From: Laura Gibbons
Sent: 20 August 2018 11:47
To: Planning.Responses
Subject: RE: Planning Consultation on: AL/84/18/DOC

Engineers Comments Regarding Condition 3- Surface Water Drainage

APPLICATION NO: **AL/84/18/DOC**

Description of Works: Approval of details reserved by condition imposed under AL/105/16/HH relating to condition 3-surface water drainage.

PRELIMINARY
NOT FOR CONSTRUCTION
DESIGN SUBJECT TO THE APPROVAL OF:
PLANNING AUTHORITY
BUILDING CONTROL

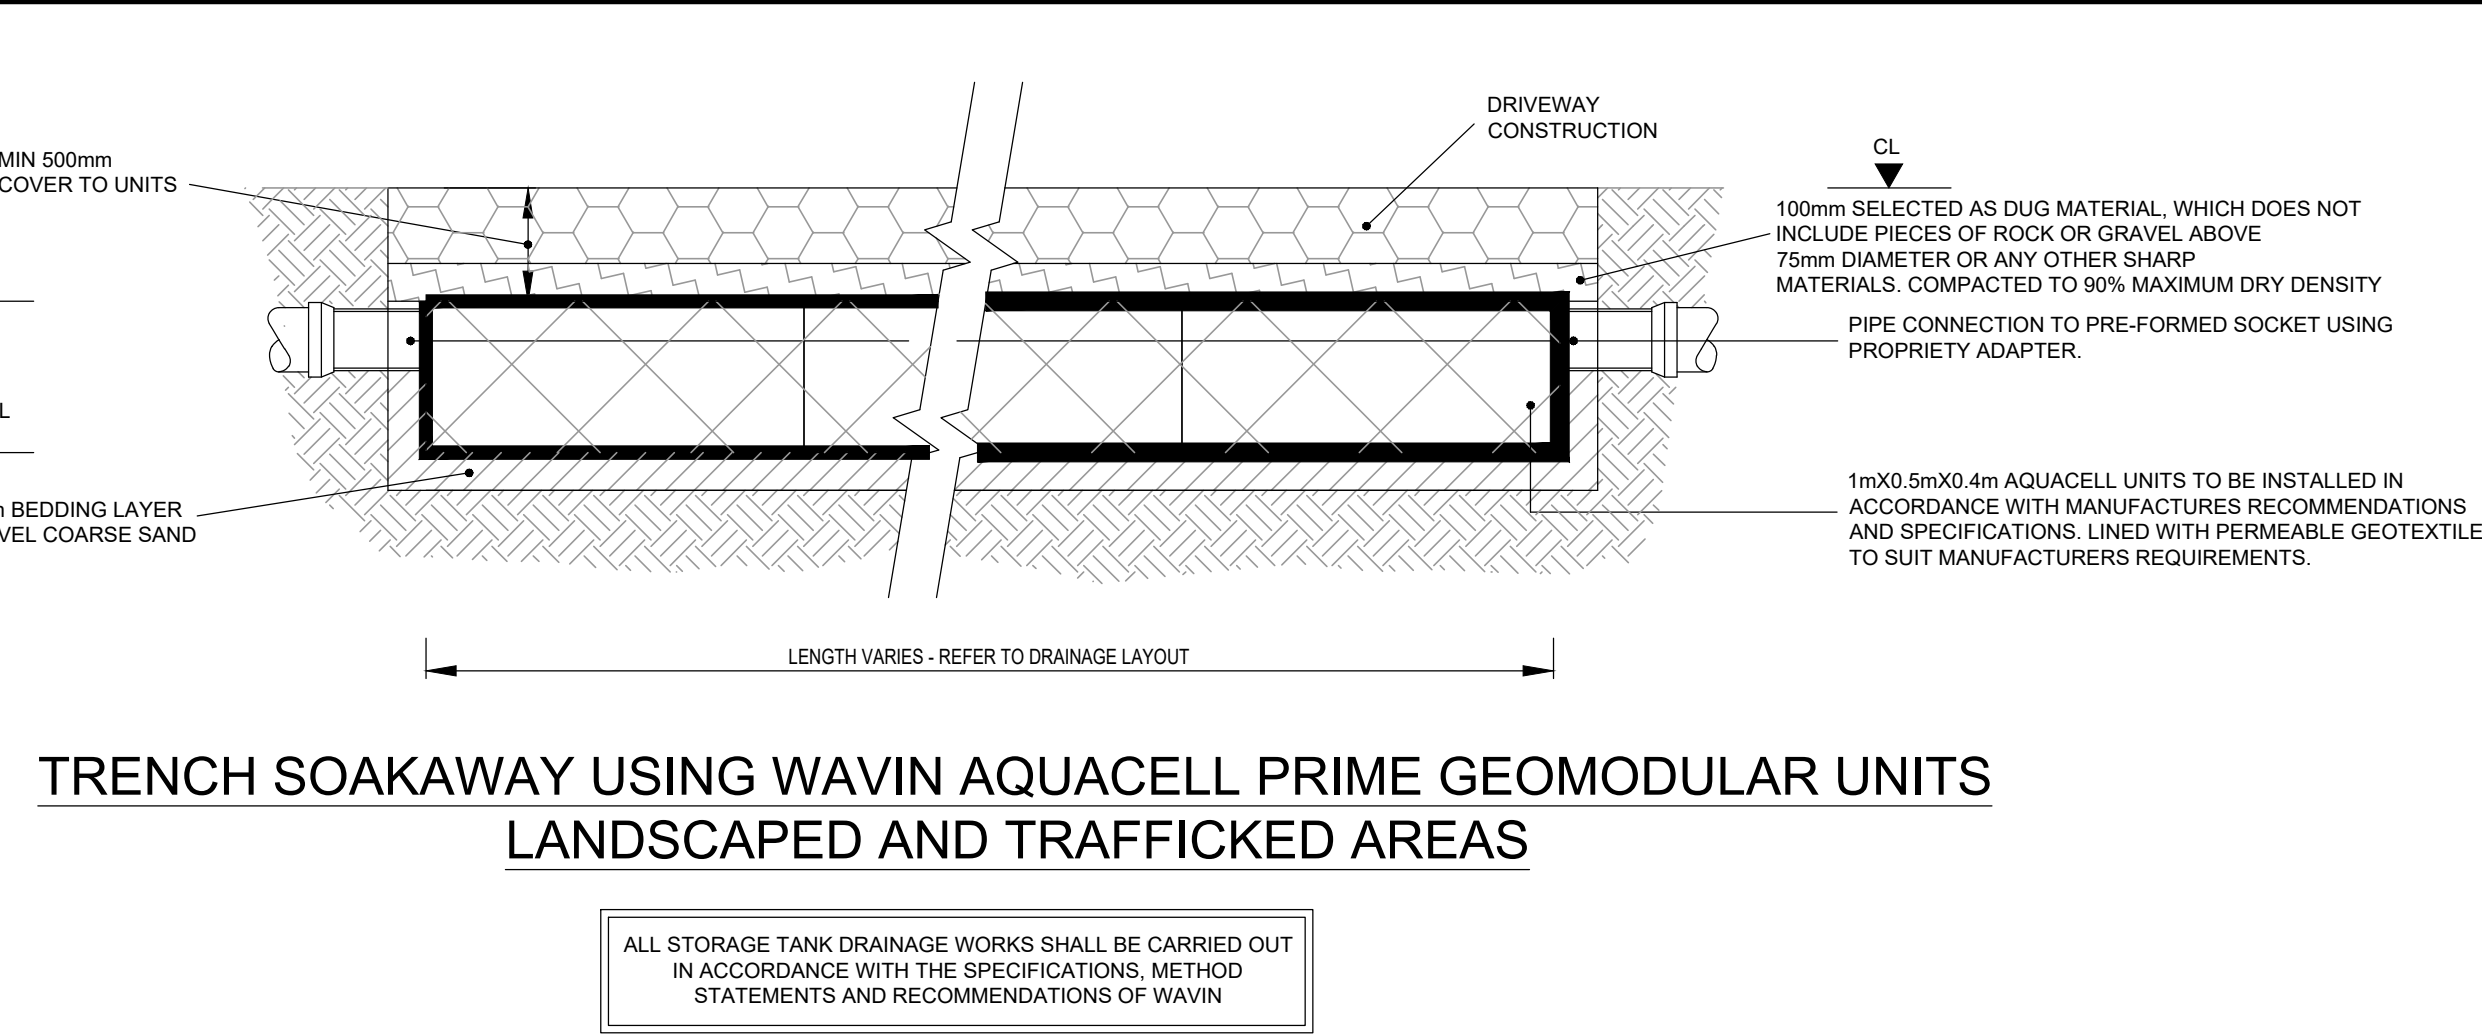
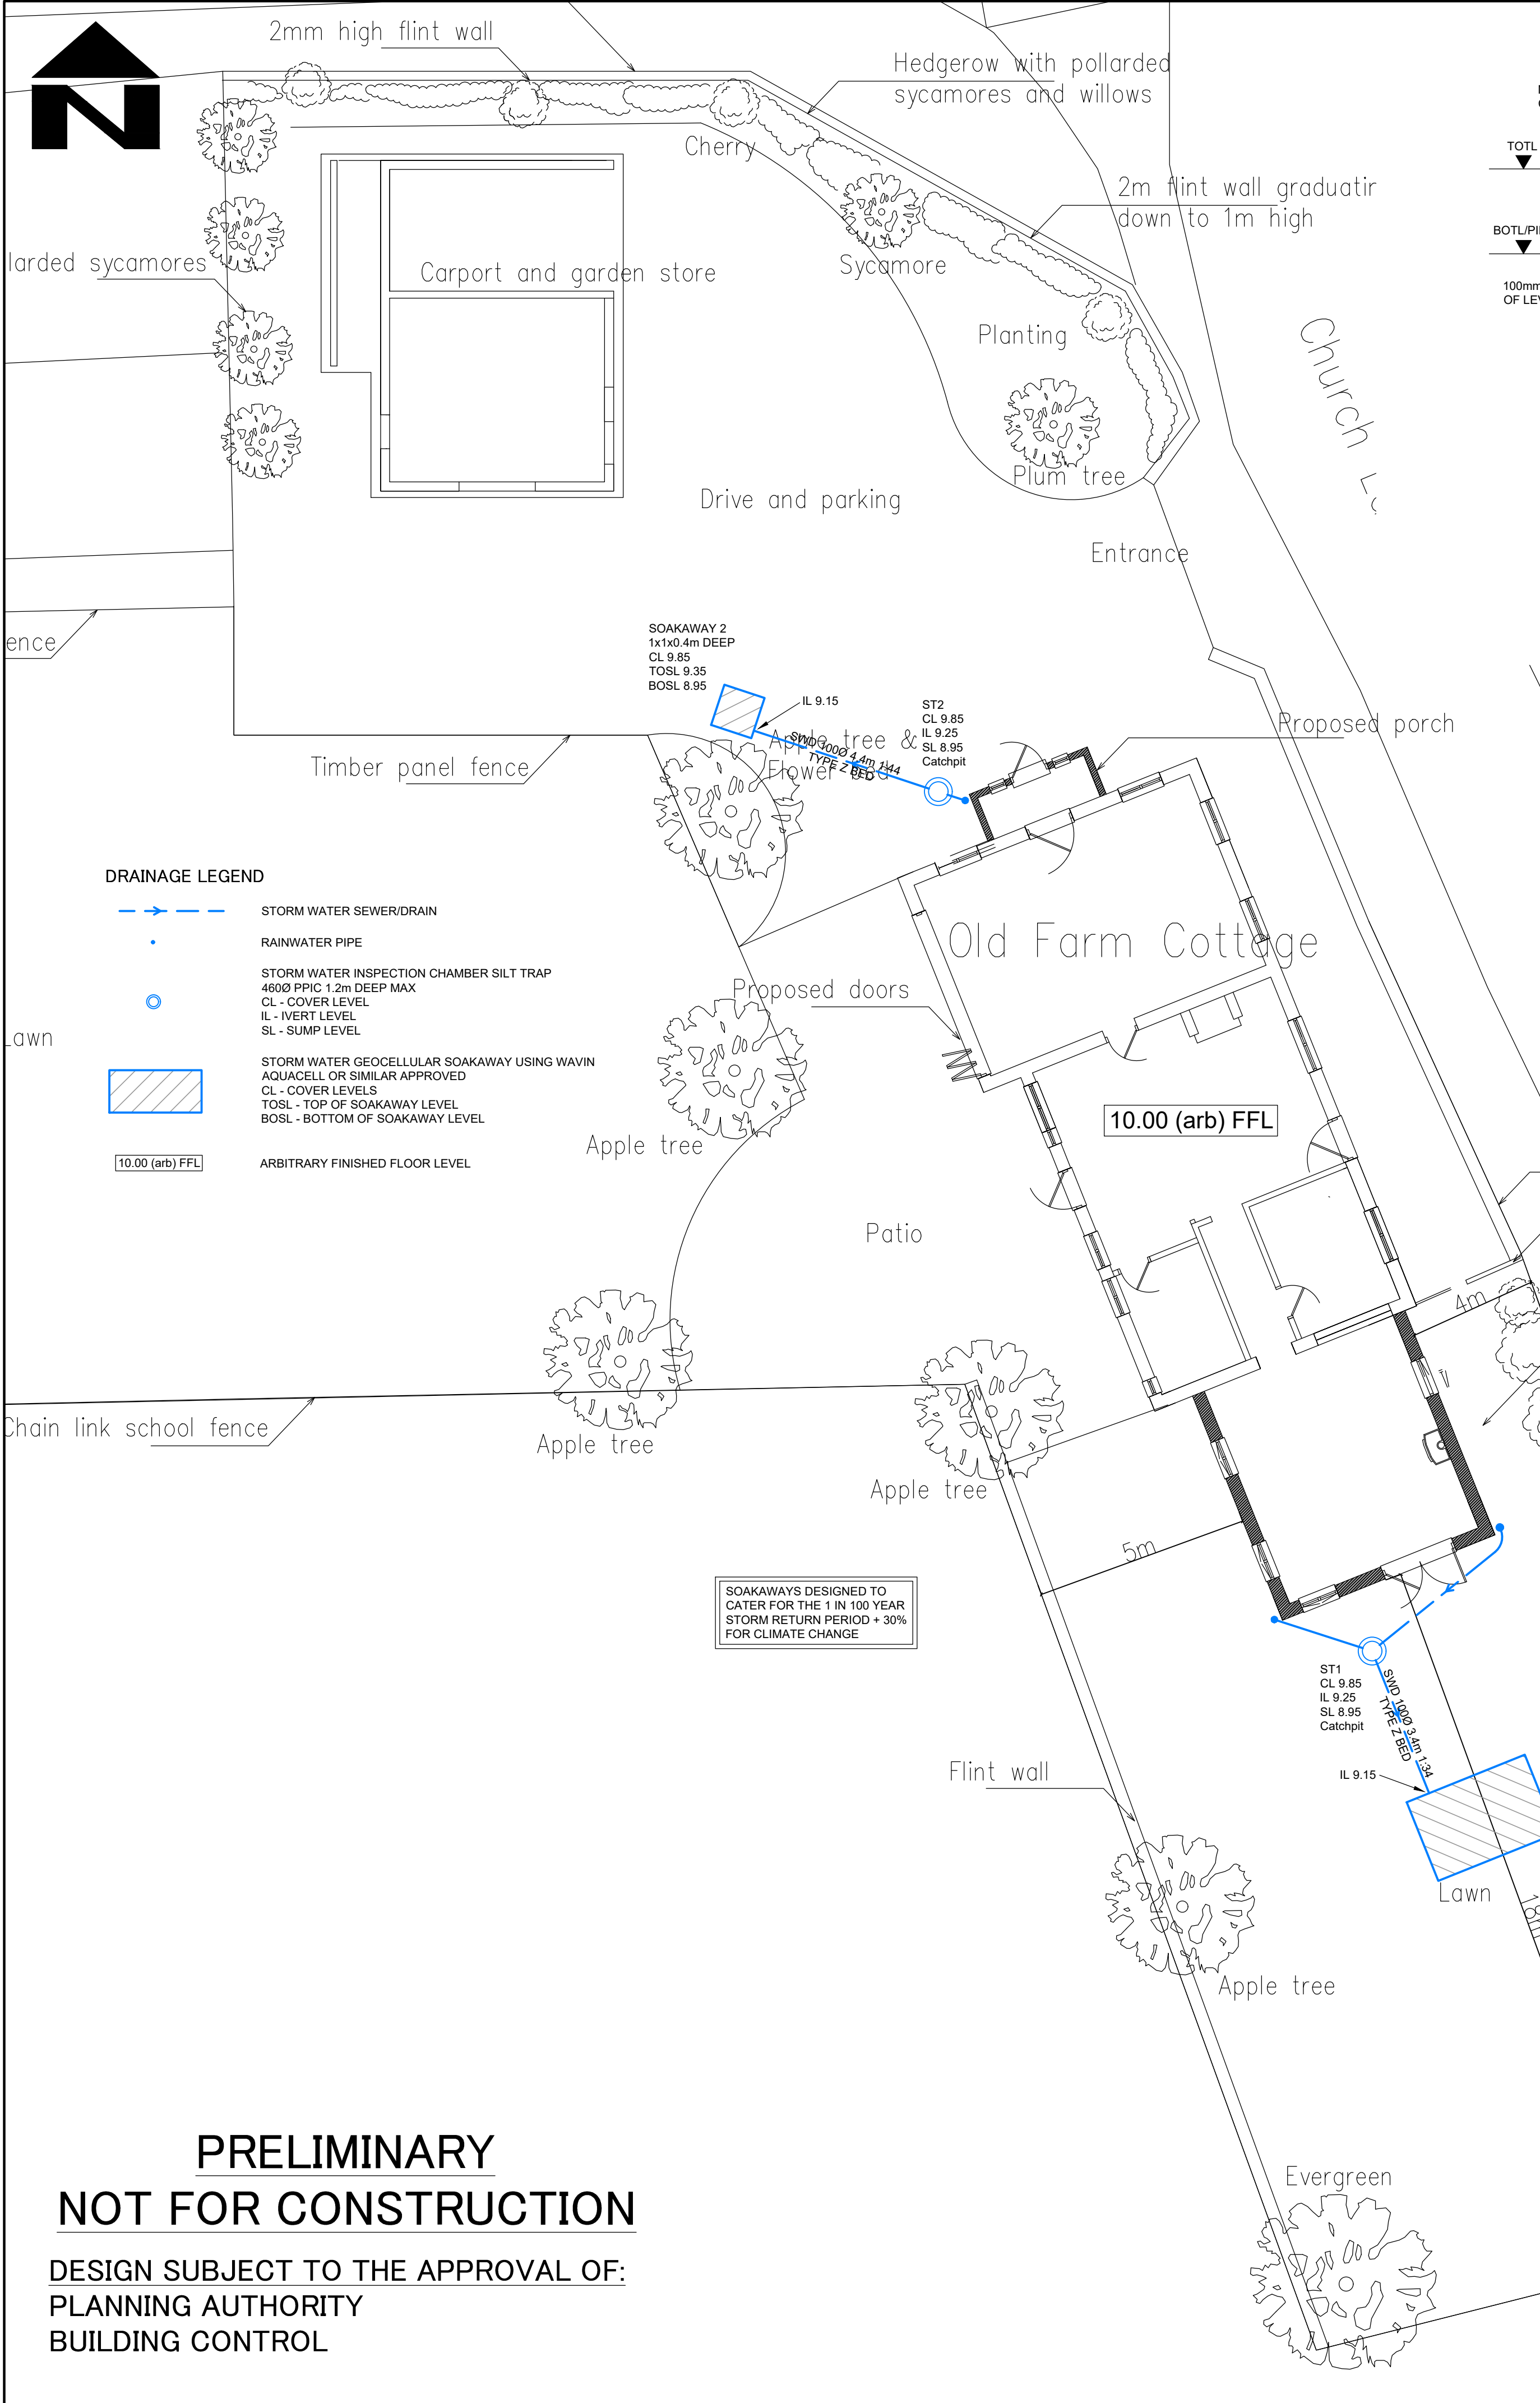
1. The provided details state that the soakaway crates are to only be used in landscaped areas, yet they are being used under an area of driveway. Please clarify if the crates to be used and cover details are sufficient to take loading from vehicles.
2. The incoming pipes to soakaways should be located as high in the soakaways as possible. Can any adjustment be made to the design to ensure the pipes come in at a higher level, but that the base of the infiltration structures is set no lower than 1m.
3. Please provide details for the pipe cover details to ensure these meet building regulation requirements. I.e. concrete bed and surround where cover depths are limited.
4. Please also specify pipe invert levels, diameters, and slopes on plan.
5. No calculations were provided, but my own checks completed on the soakaway dimensions demonstrate that sufficient area has been provided.
